From: Charlotte Watkins
Sent: 20 April 2020 11:51
To: Gemma Magnuson
Subject: RE: 20/00641/F

Proposed Alterations to existing Rear Single Storey Extension on the Yews, Main Street, Sibford Green, OX15 5RT for Mr & Main.

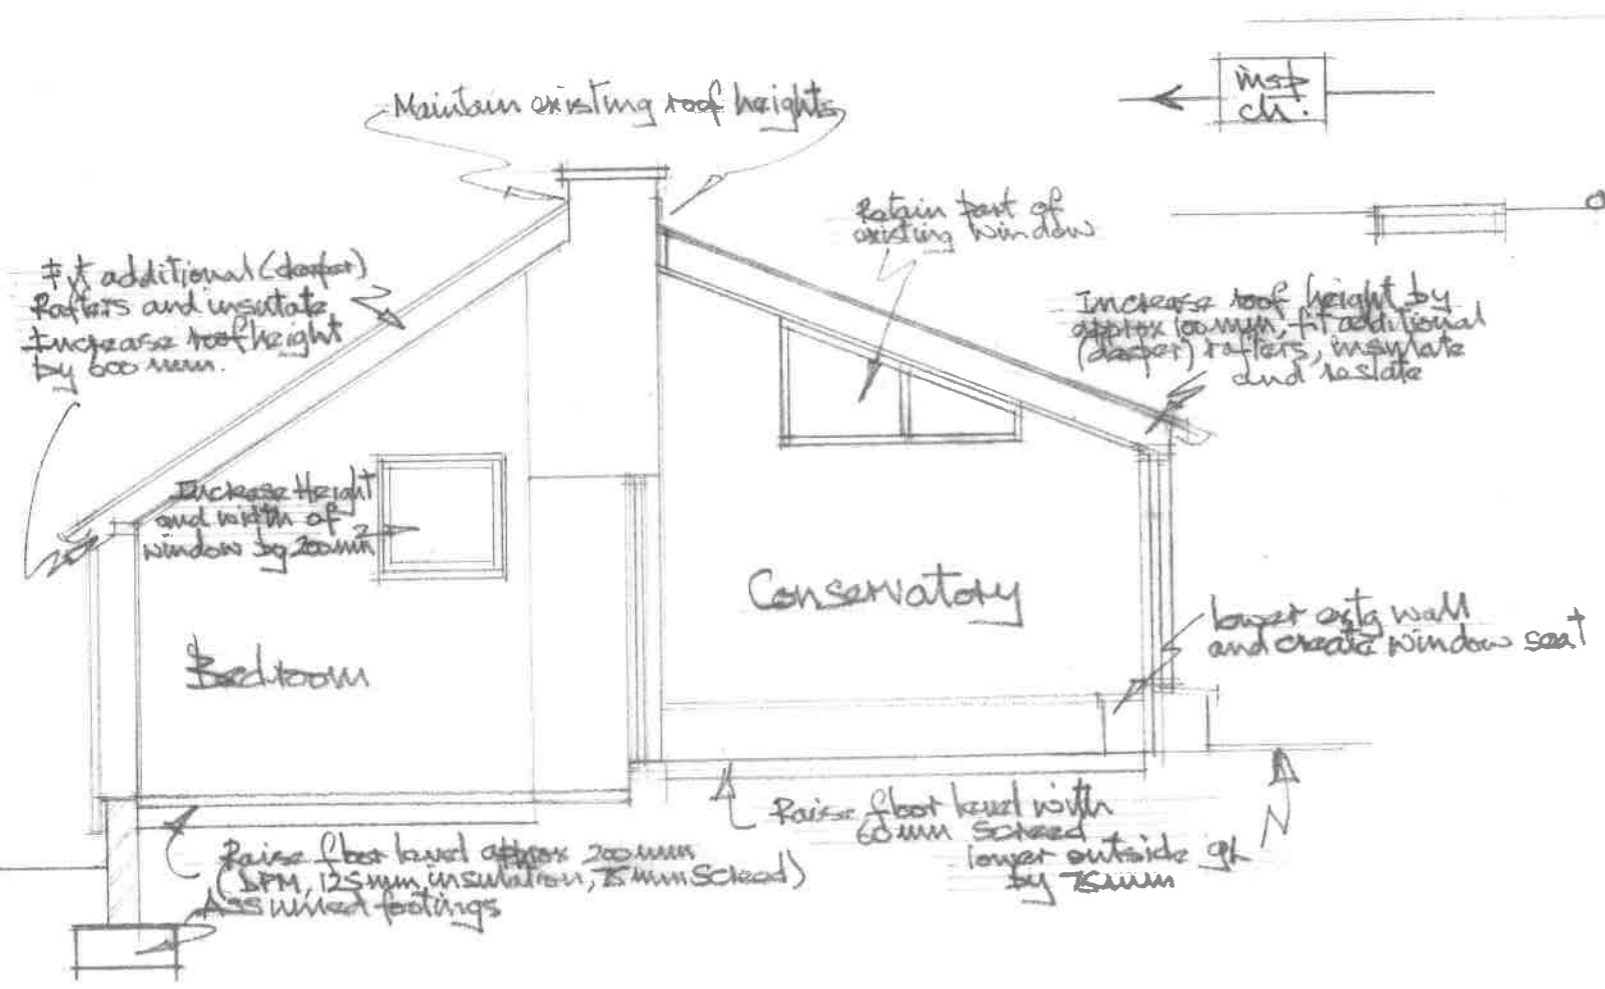
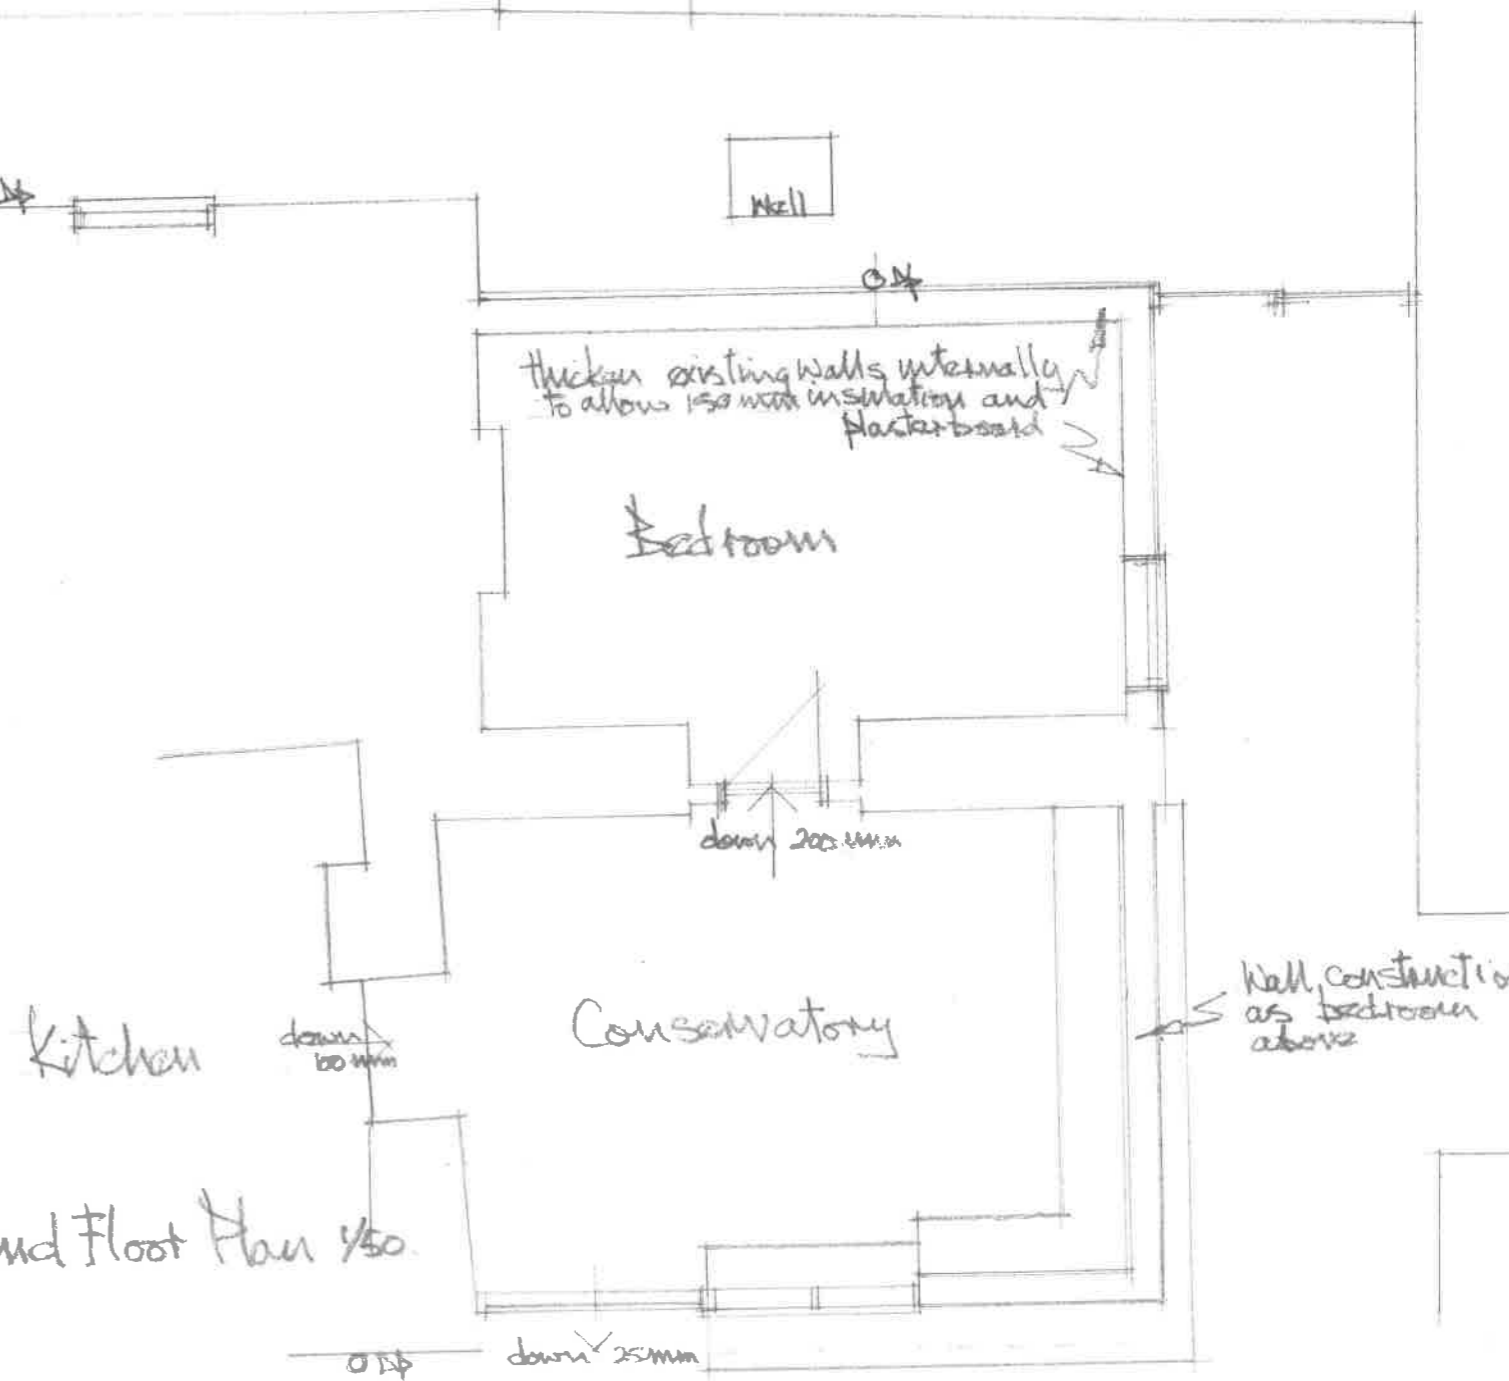
Generally from the photos sent on I think that bats are less likely to be present in this part of the dwelling and therefore less likely to be affected. The weatherboarding is not feathered and much of the other part of the building is glazed. I would be content therefore for this application to proceed without a bat scoping survey but with the addition of a bat planning note to ensure the applicant is aware of the law pertaining to bats, that there is always a possibility that bats could be present and what to do should any bats be discovered during works.
